Natural England's additional guidance on the assessment of guillemot and razorbill displacement impacts for the Hornsea Project Four Offshore Wind Farm

Planning Inspectorate Reference EN010098

20th June 2022

Figure 1: Monthly guillemot abundance within Hornsea Four across two-years of baseline survey. Bio-seasons (breeding and non-breeding) are defined by Furness (2015).

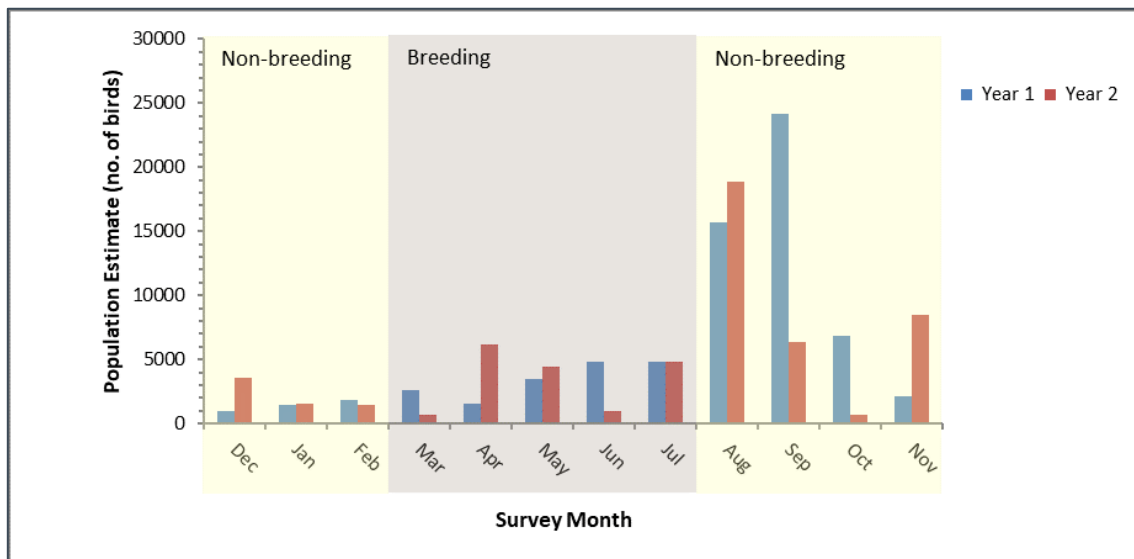
Natural England note that the Applicant introduced a new method for estimating seasonal mean peak abundance estimates for guillemot within their DCO Application submission. This had not been used in the previous draft submitted to Natural England within the evidence plan process and we had not requested or approved this change to the assessment methodology.

Within the DCO Application, the Applicant adopted a "weighted" approach to the calculation of seasonal mean peak abundance estimates. These values are used in the assessment of displacement for both EIA and HRA. The approach splits the single non-breeding season into post-breeding (August to September), migration-free winter (October to November) and return migration (December to February) periods. The methods are detailed in the Displacement Analysis Annex (Section 1.4.4) submitted within the Application¹.

This approach was employed to reduce the influence of the large peaks that occurred during the post-breeding (August and September) period. The Applicant suggests these peaks are short-lived and inflate the seasonal mean peak estimate for the non-breeding season leading to over-precaution in assessing potential displacement.

Natural England do not agree with this approach. It fails to adequately capture impacts on birds during the chick rearing/moult period when there are large aggregations of present in the

project area and individuals are likely to be particularly vulnerable to displacement. The Applicant has acknowledged there are likely to be distinct ecological/bio-seasons within the wider non-breeding period, but instead of assessing these separately, as for other species such as razorbill, they have chosen to weight the estimates. This results in a significant under-representation of potential impacts at a critical time of year for the auk life-cycle.

Natural England advise the use of the following seasons to derive seasonal mean peak abundance estimates for EIA and HRA for guillemot. These should then be subject to the accompanying overall apportioning rates for Flamborough & Filey Coast Special Protection Area (FFC SPA) for HRA:

- **Breeding season (March to July): 100%** - this assumes 100% of all birds are adults from FFC SPA and represents the worst-case scenario against which the Applicant’s approach (56%), based on adult apportioning from Furness (2015) and applying a sabbatical rate, can be considered.

- **Chick rearing/moult (August and September): 60%** - this is based on productivity information from FFC SPA in 2016 (0.64 chicks per pair) and 2017 (0.68 chicks per pair excluding a plot that was disturbed) during the baseline survey period. This suggests that, on average, there would be 0.33 chicks per breeding adult, which is equivalent to 67% adults at the end of the breeding season (Aitken et al. 2016, Babcock et al. 2017). Taking into consideration the likely connectivity between FFC SPA and the Hornsea Project Four area at this time and allowing for some degree of dilution by adults from other colonies to North, we suggest that it is suitably precautionary to assume that around 90% of the adults come from FFC SPA. Notwithstanding any new evidence, this would equate to approximately 60% of all guillemots in the Hornsea Project Four area being adults linked to the FFC SPA.

- **Non-breeding (October to February): 4.41%** - this is based upon the standard BDMPS approach (Furness 2015).
